From: Paul Cann
Sent: 09 February 2018 17:08
To: Planning.Responses
Subject: RE: Planning Consultation on FG/22/18/DOC

Surface Water Drainage Condition

Site Address: Onslow Caravan Park Onslow Drive Ferring BN12 5RX

Description of Works: Application for approval of details reserved by conditions imposed under planning permission FG/37/17/PL relating to condition No. 3 (Schedule of materials), 4 (Surface water drainage), 6 (Construction Management Plan) & 8 (Landscaping scheme)

Simon Jones-Parry BSc CEng MICE Chartered Civil Engineer Swans Farm Winchfield Hook RG27 8DB Tel 01256 704940			
Island Meadow Parks		DRAINAGE PLAN - PLANNING CONDITION 4	
NEW MACHINERY STORE AT ONSLow DRIVE, FERRING		Scale 1:250	Date 03.11.17 Drawing No 100

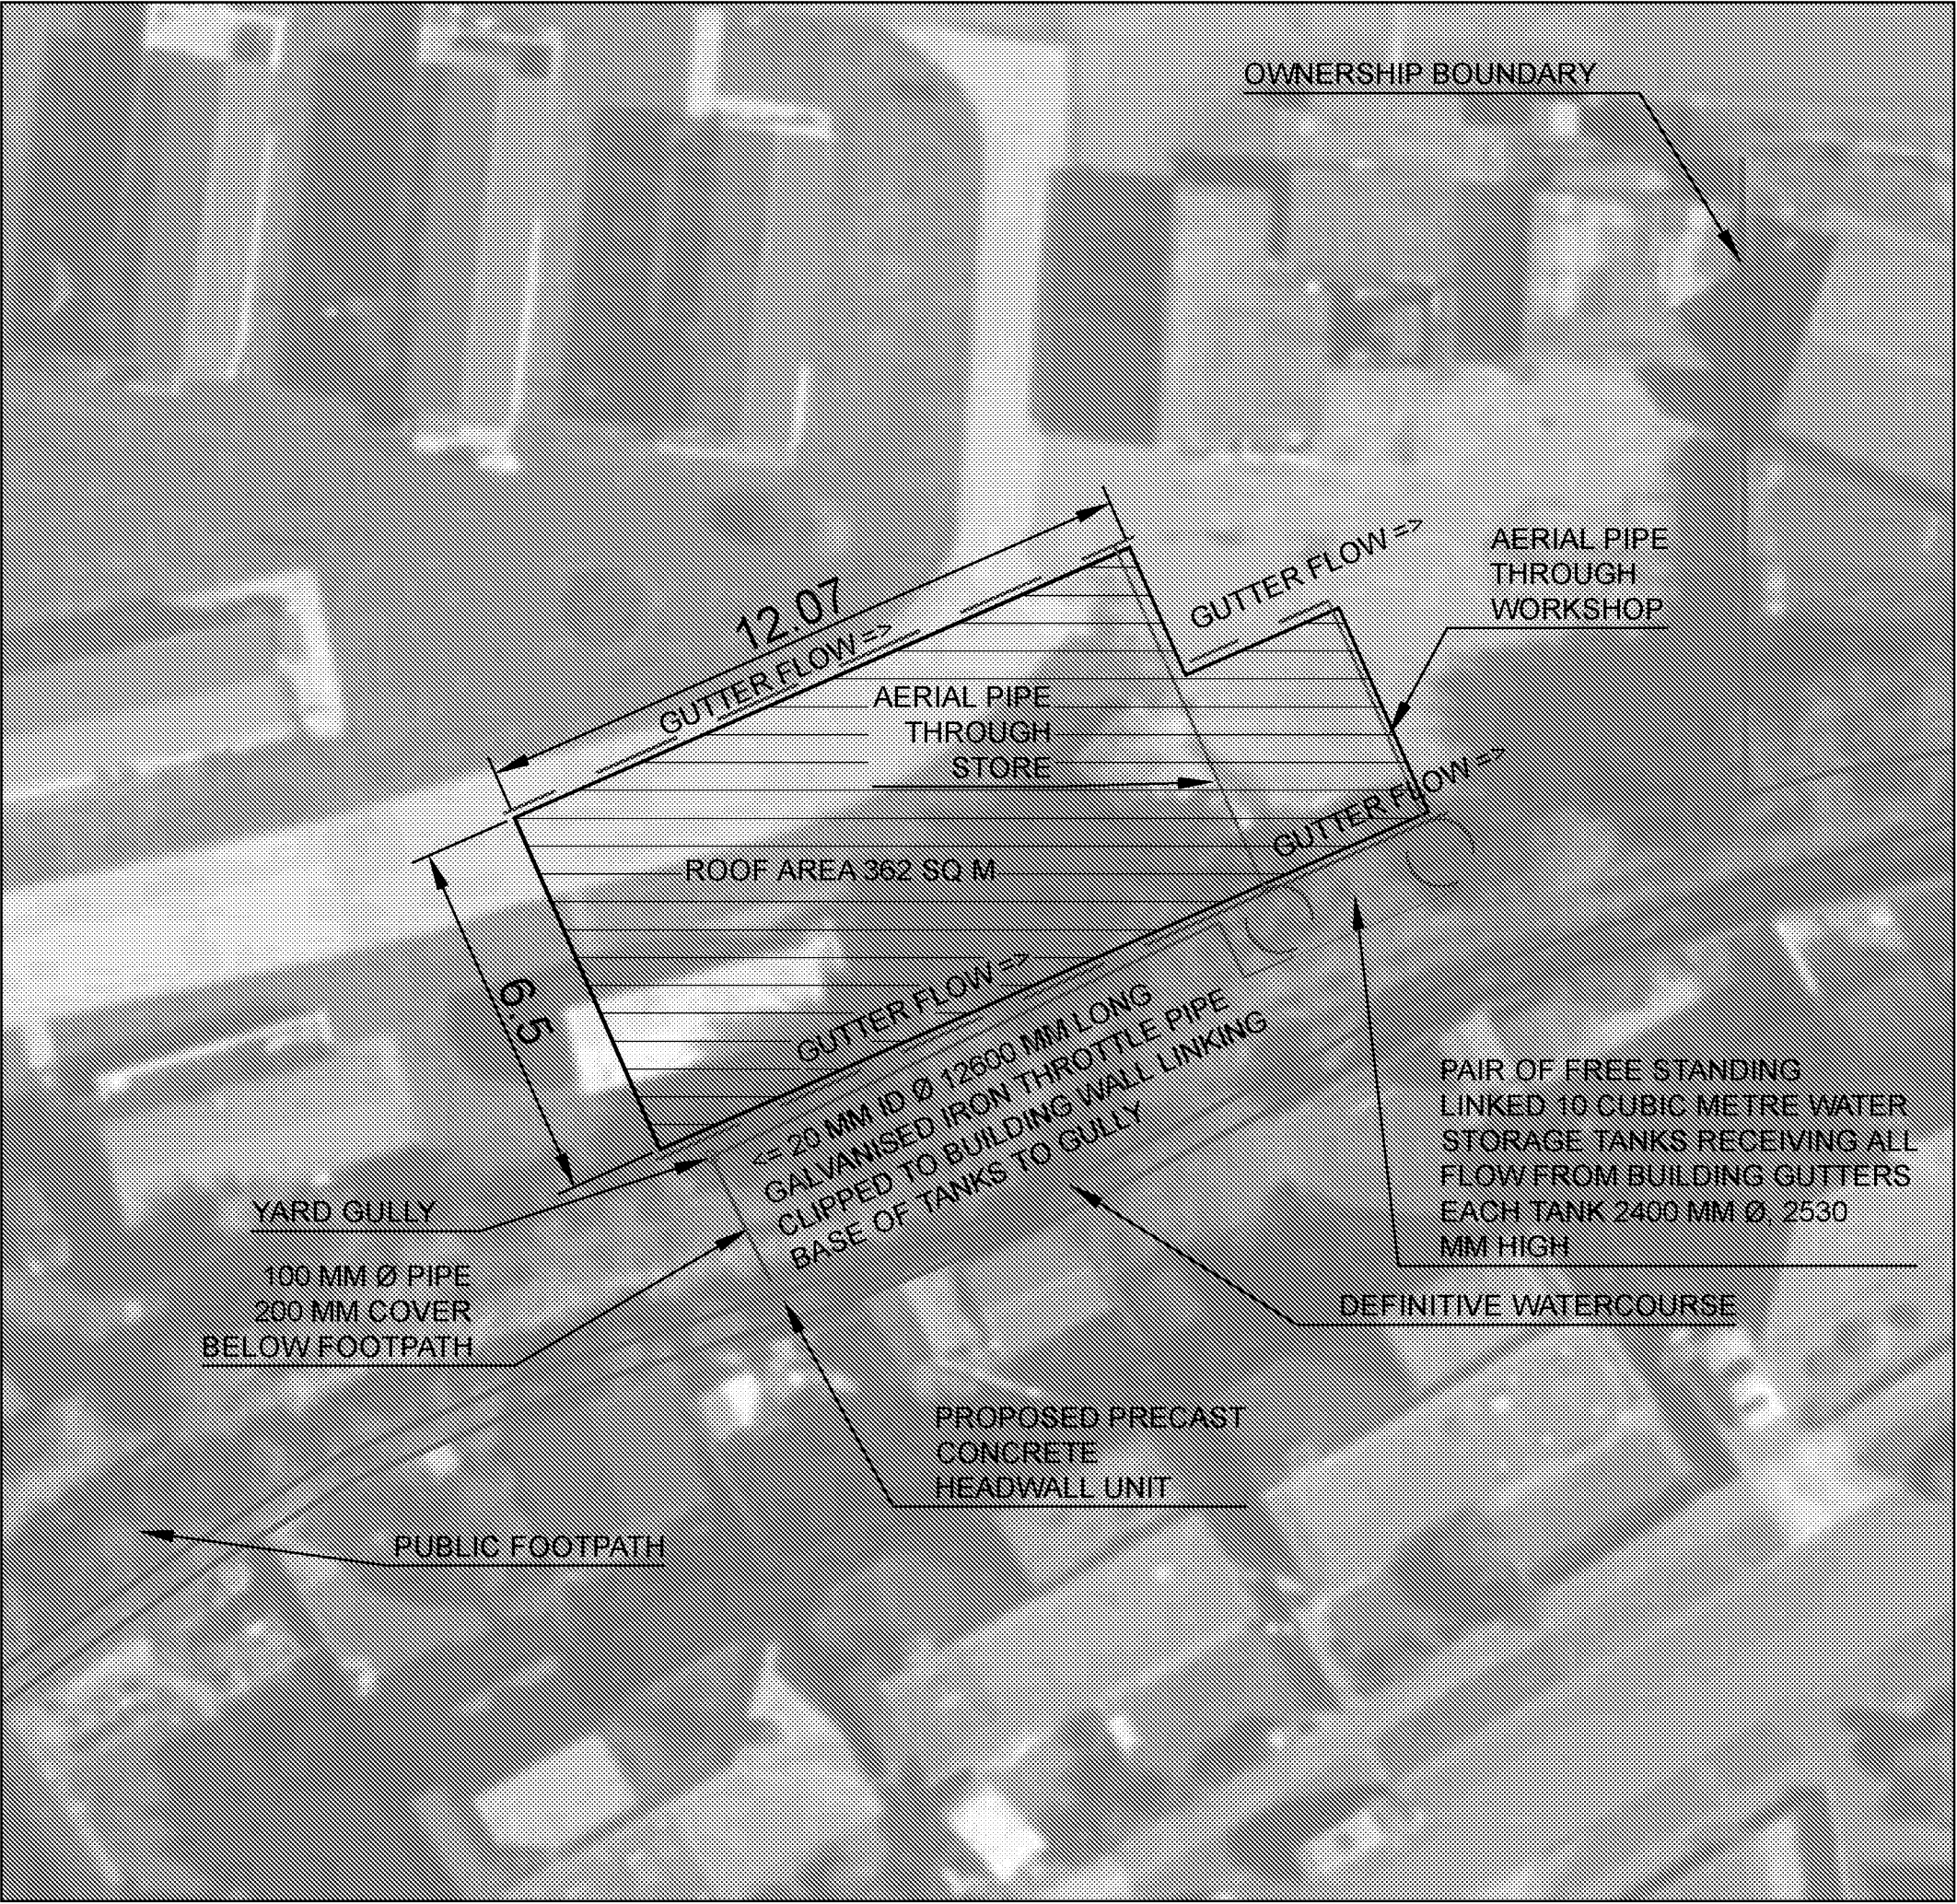
2. The applicant will need to provide a fully detailed drainage plan including cover/invert levels/ditch bed levels/all pipe diameters, gradients, etc.

3. Full construction details will be required including the gully/headwall/any manholes/silt traps, etc
4. More detailed information is required on the above ground storage tanks in terms of inlet and outlet levels, etc. The proposed restricted discharge is noted, however, the pipe diameter is a concern ie.20mm. The system needs to be robust in terms of prevention of pipe blockage and the tanks need to accommodate the 1 in 100 year event + 30% allowance for climate change. Storm durations from and including 15 mins need to be accommodated. How the flows will be restricted required more discussion.

5. Flows from any new hardstanding's need to be accommodated in the system. Please confirm/verify/detail arrangements.
6. Silt must be collected/controlled via sumps.

7. The headwall must be of such construction as not to encroach into the profile/flow area of the ditch and also mindful of the public right of way footpath running alongside, as not to present a safety issue.
